MORGAN AND MORECAMBE OFFSHORE WIND FARMS: TRANSMISSION ASSETS

Annex 2.3 to Applicants' Response to Deadline 3 submissions from Statutory Consultees and other organisation: Fylde Borough Council (REP3-082)

Document Numbers:
MRCNS-J3303-JVW-19134MOR001-
FLO-CON-CAG-RPT-0114
Document Reference: S_D4_2.3

Table 2.1: REP3-082 – Fylde Borough Council's Responses to ExQ1

**Figure 4.2: Designated sites (MCZ, SPA, SAC, Ramsar sites and SSSI) in the vicinity of the Transmission Assets offshore infrastructure search area**

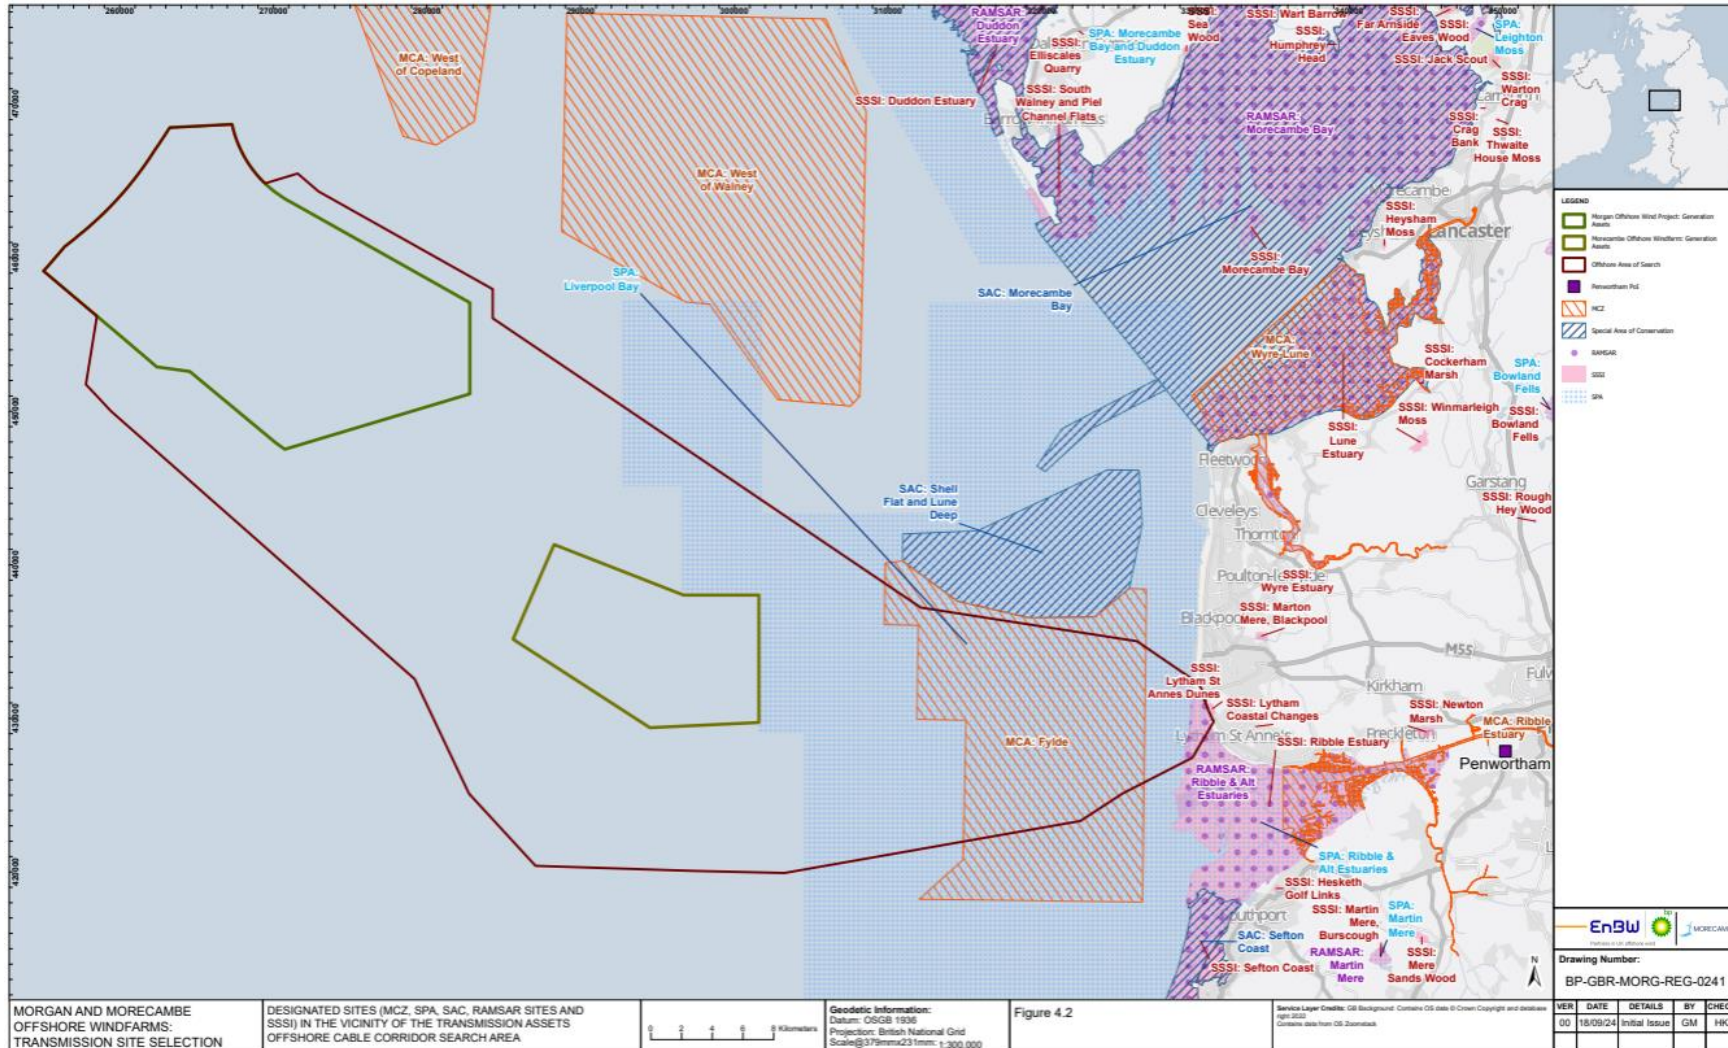
Reference	Question To	ExA Question	IP submission	Applicants' response
		<p>028] makes no reference to the Green Belt and it is not included in the constraints shown on Figure 4.2. There is no evidence of the Green Belt being considered at this stage, noting that Table 4.7 [AS-028] which includes the Green Belt relates only to Stage 3c (refinement of onshore substation search areas for PEIR).</p> <p>a. Clarify to what extent has the consideration of the Green Belt been underplayed in the substation site selection process, given that it does not appear to have been considered at Stage 2c which defined the search area the subject of further consideration at Stage 3c?</p> <p>b. Taking account of any relevant policy and case law, to what extent does it need to be demonstrated that site locations outside of the Green Belt have been reasonably avoided?</p> <p>c. In considering the final location of the two</p>	<p>The existence of an alternative site for a particular development may be a material consideration. In <i>Trusthouse Forte Hotels Ltd. v Secretary of State for the Environment</i> (1986) 53 P. & C.R. 293, Simon Brown J., as he then was, stated five basic principles (at pp.299 and 300), including '(1) ... [the] fact that other land exists ... upon which the development would be yet more acceptable for planning purposes would not justify the refusal of planning permission upon the application site; (2) [where], however, there are clear planning objections to development upon a particular site then it may well be relevant and indeed necessary to consider whether there is a more appropriate alternative site elsewhere. ... ; (3) [instances] of this type of case are developments, whether of national or regional importance, such as airports, ... coalmining, petrochemical plants, nuclear power stations and gypsy encampments ... ; (4) [in] contrast to the situations envisaged above are cases where development permission is being sought for dwelling houses, offices ... ; [and] (5) [there] may be cases where, even although they contain the characteristics referred to above, nevertheless it could properly be regarded as unnecessary to go into questions of comparability[, and this] would be so particularly if the environmental impact was relatively slight</p>	<p>taken out of context and do not go on to consider subsequent reasoning contained within the respective judgments. For example, the Applicants would note that in the R (on the application of Luton Borough Council) v Central Bedfordshire Council [2015] EWCA Civ 537, this judgment concluded there was no potential viable alternative site that was obviously material for the respondent to have considered. The Applicants have provided a response previously as to why they do not consider Stanah to be an obviously material alternative (see section 4 of REP3-041).</p> <p>The Applicants agree with FBC (as set out in the Applicant's Response to the Examining Authority's Written Questions, REP3-056, Q1.2.3), that there is no specific policy requirement in the NPPF or relevant NPSs requiring applicants to demonstrate that there are no suitable alternative sites outside the Green Belt, and <i>Whitley</i> confirms that suitable alternatives can exist at the same time as very special circumstances to permit development in the Green Belt.</p> <p>The Applicants undertook a robust site selection and refinement exercise when identifying potential sites for the substations which is documented in Chapter 4 of the ES (AS-026) and its associated Annex 4.3 (AS-028). The Applicants also submitted a Green Belt Technical Note (REP3-069) at D3, which clearly demonstrates (with the help of an additional onshore constraints map) that there were no suitable alternative sites outside the Green Belt in which the substations could reasonably have been accommodated without resulting in significant environmental impacts.</p>
